City of Albuquerque

December 17, 1999

RE: Grading and Drainage Plan for ENVIRCO (MCT Industrial Park) (B18/D4) Submitted for Building Permit Approval, Engineer's Stamp Dated 11/16/99.

GRADING AND DRAINAGE PLAN

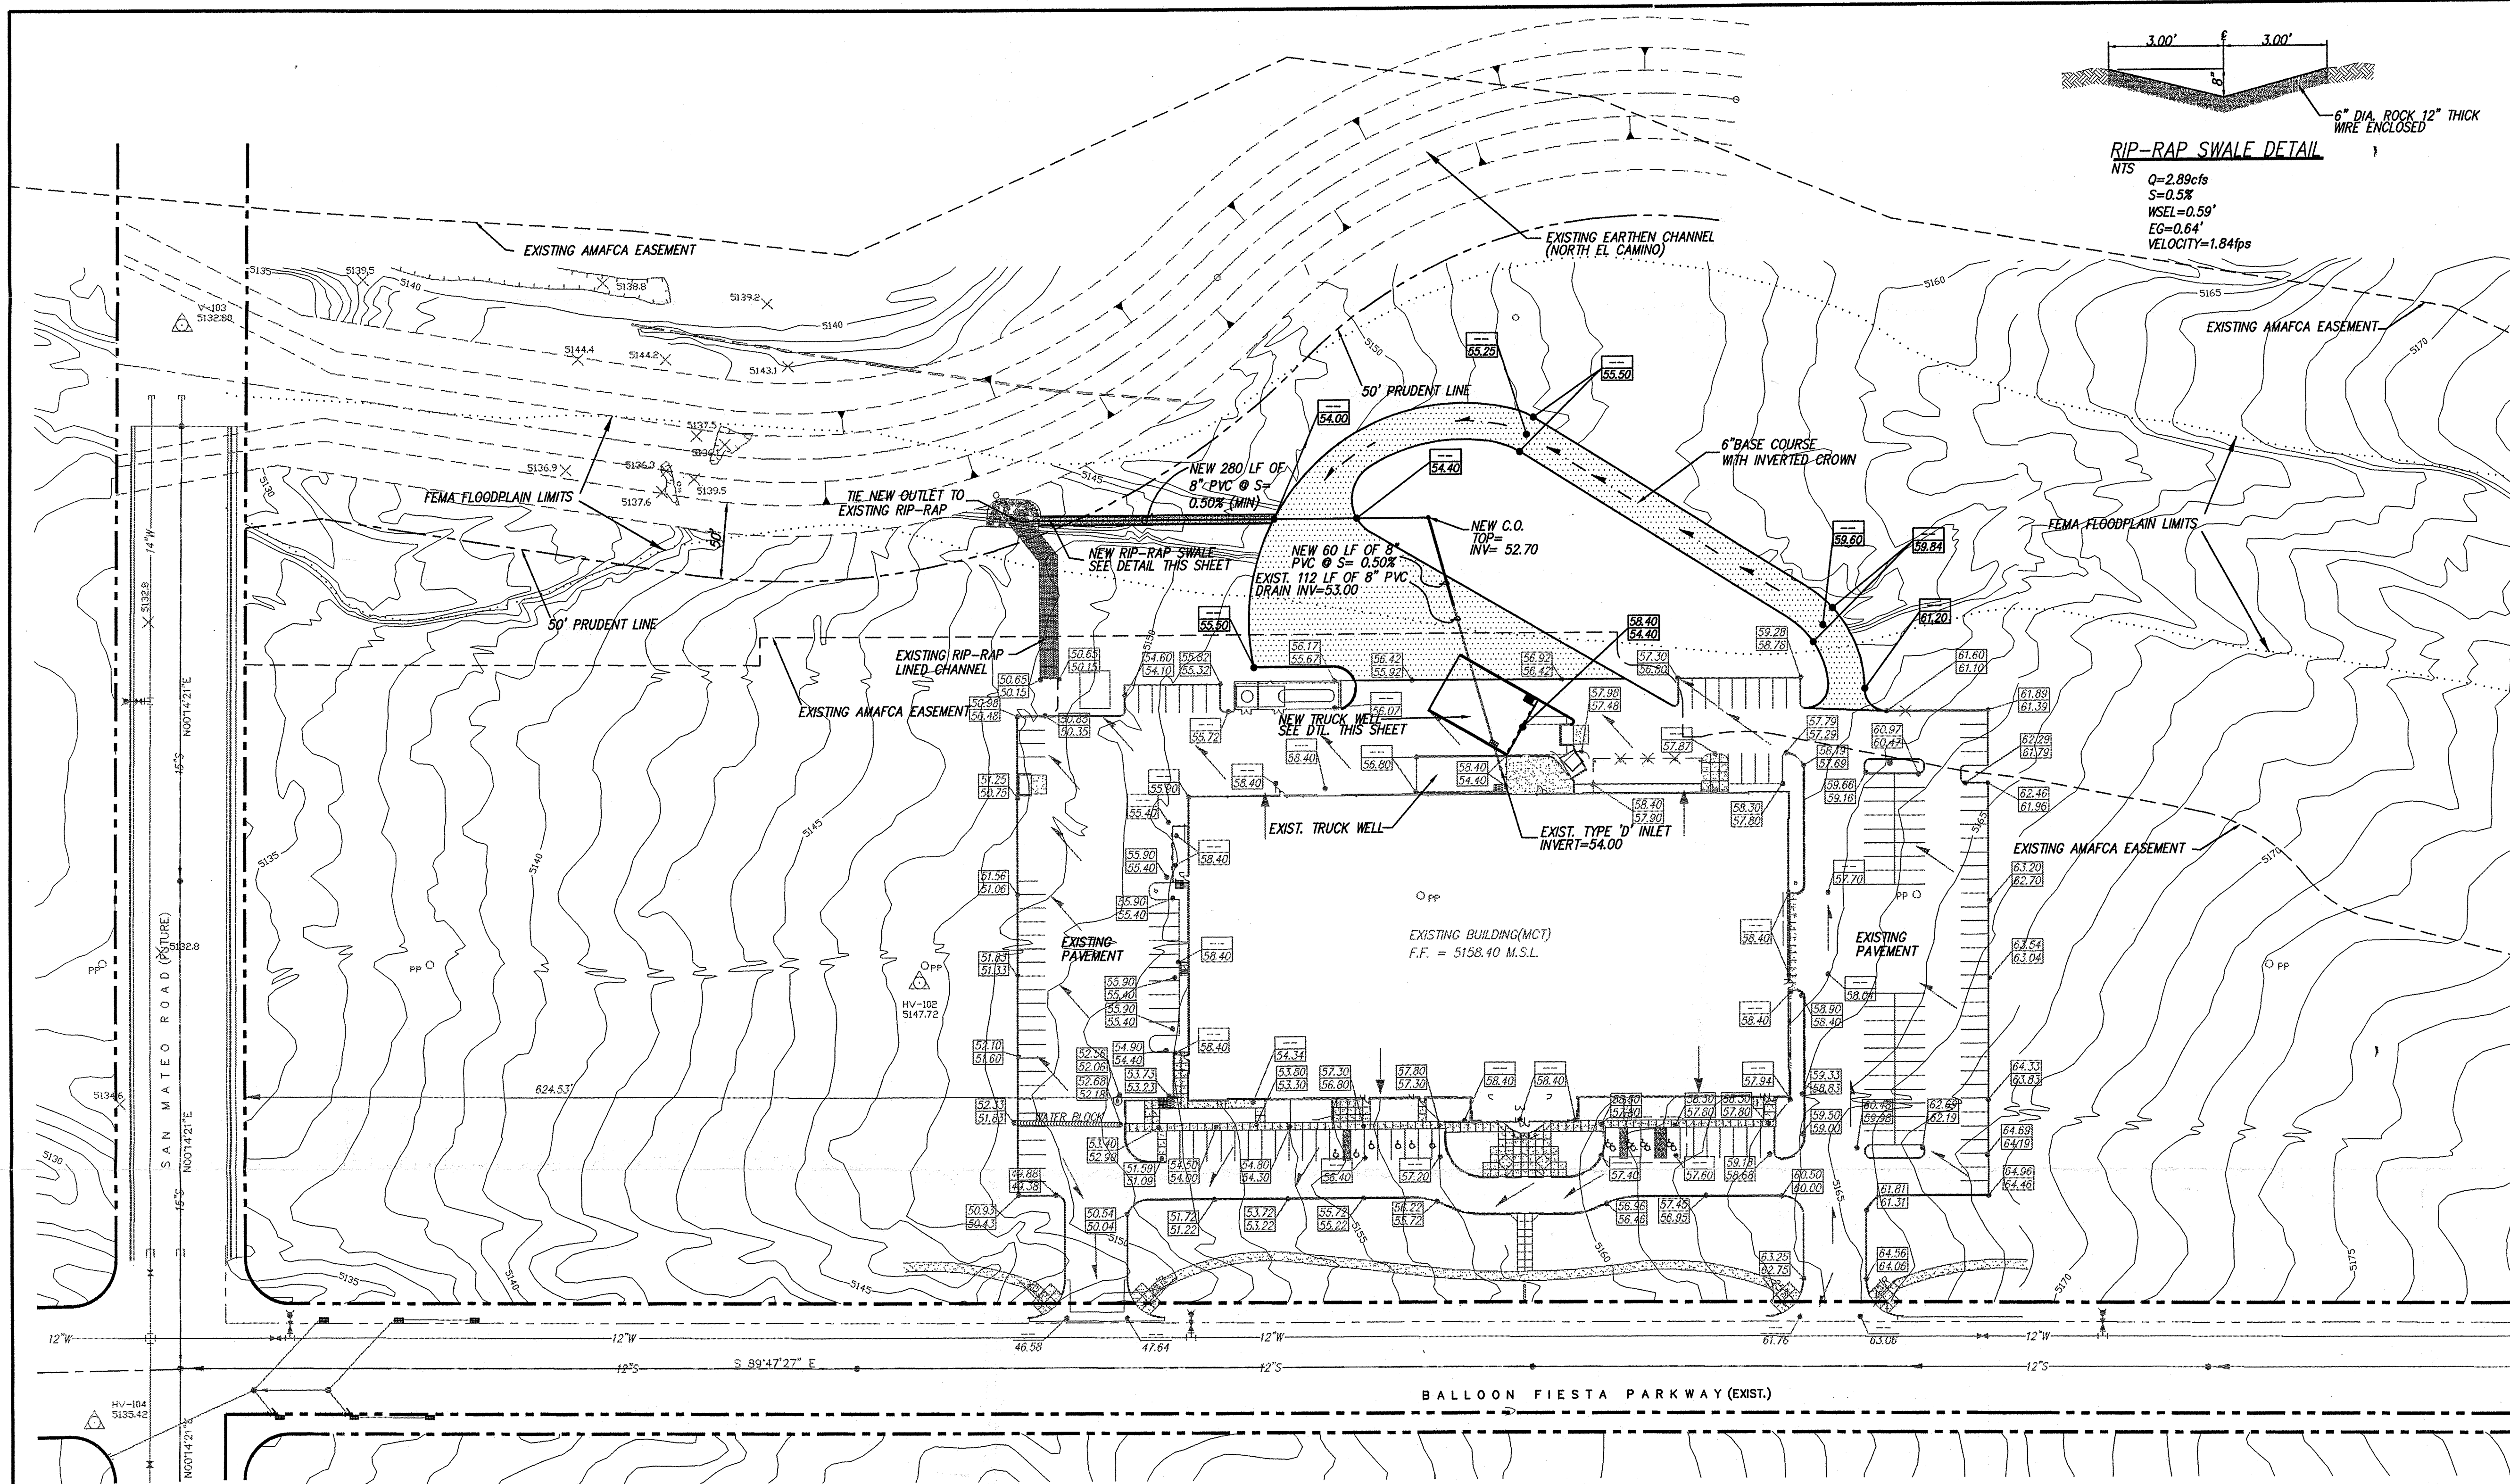
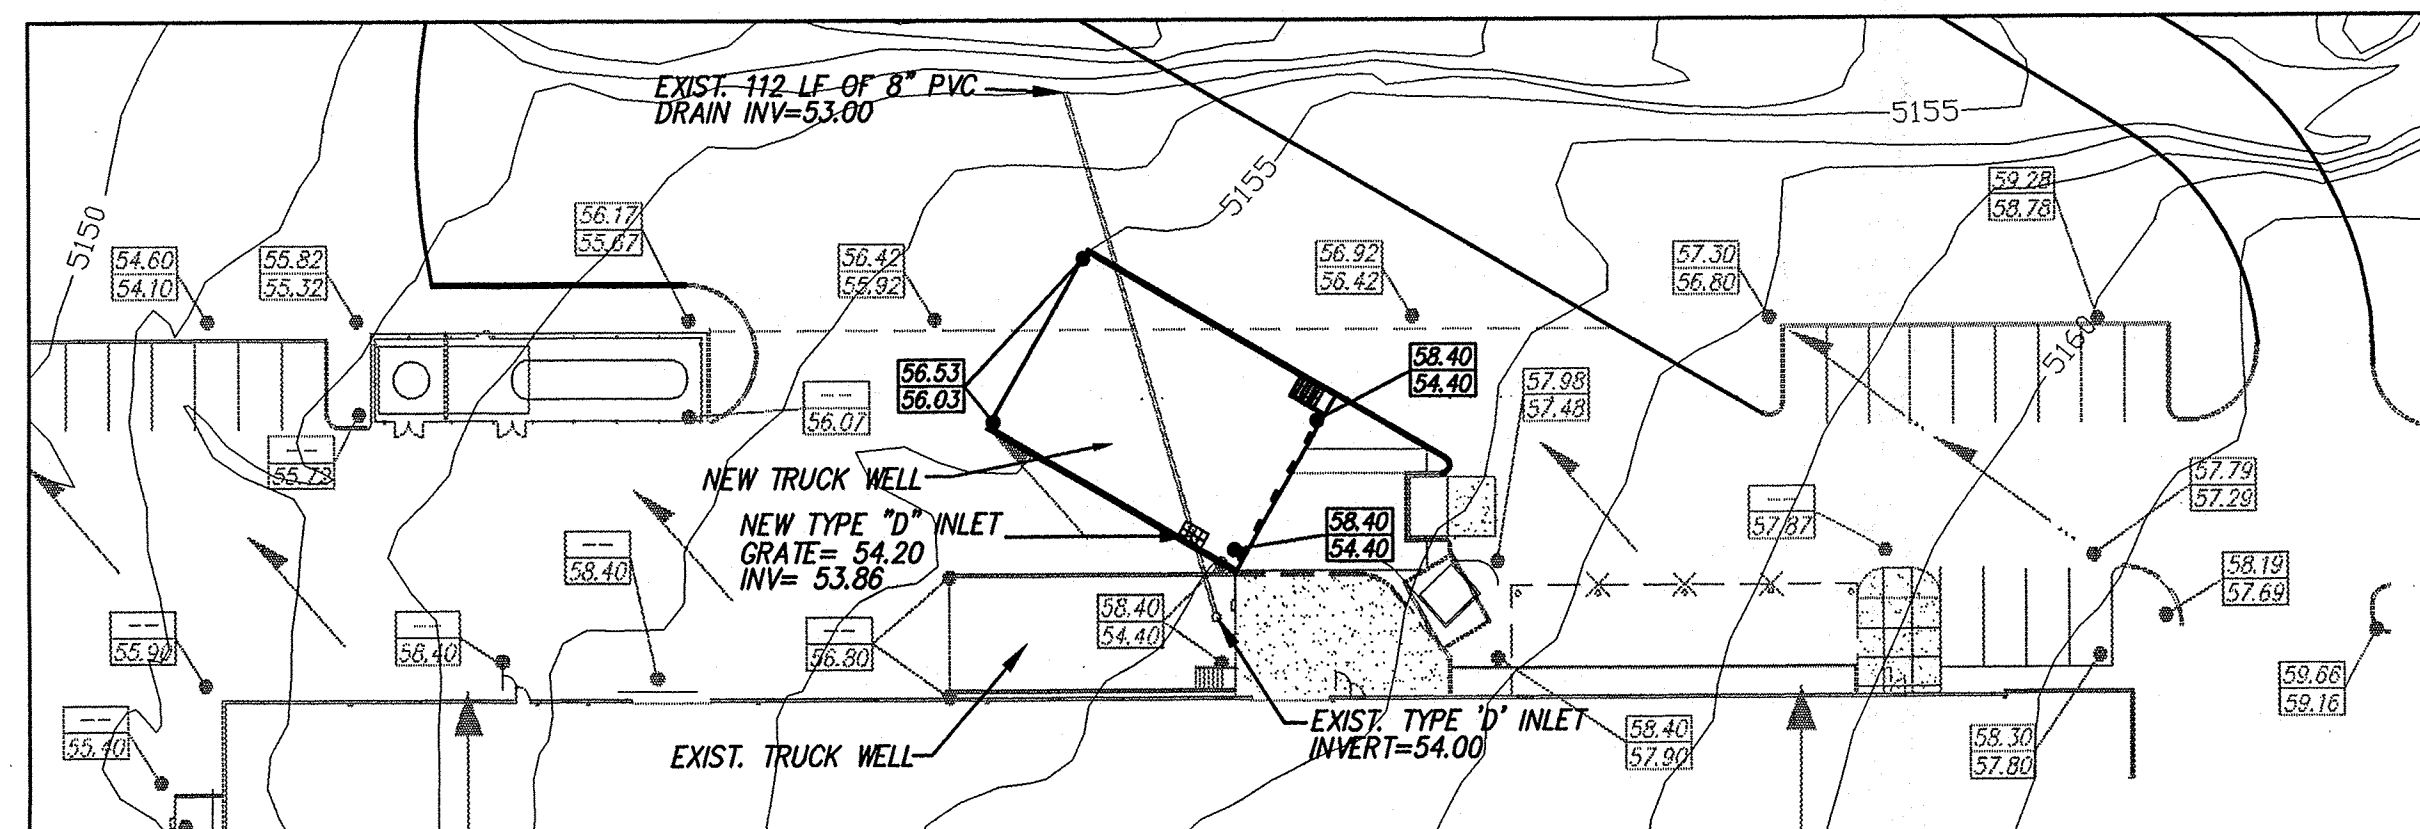
The above referenced plan proposes to use 2 feet per 100 cfs as the erosion setback limit (ESB). Although AMAFCA has no problem with this concept, the City requires that the ESB be estimated using 6 feet per 100 cfs, or calculated using the methods in AMAFCA's Sediment and Erosion Design Guide. It appears that no justification for a variance for this requirement has been provided.

The City does not allow any hard improvements, including paving, within the ESB without erosion protection. Please revise the ESB on the plan and show the erosion protection for the proposed improvements.
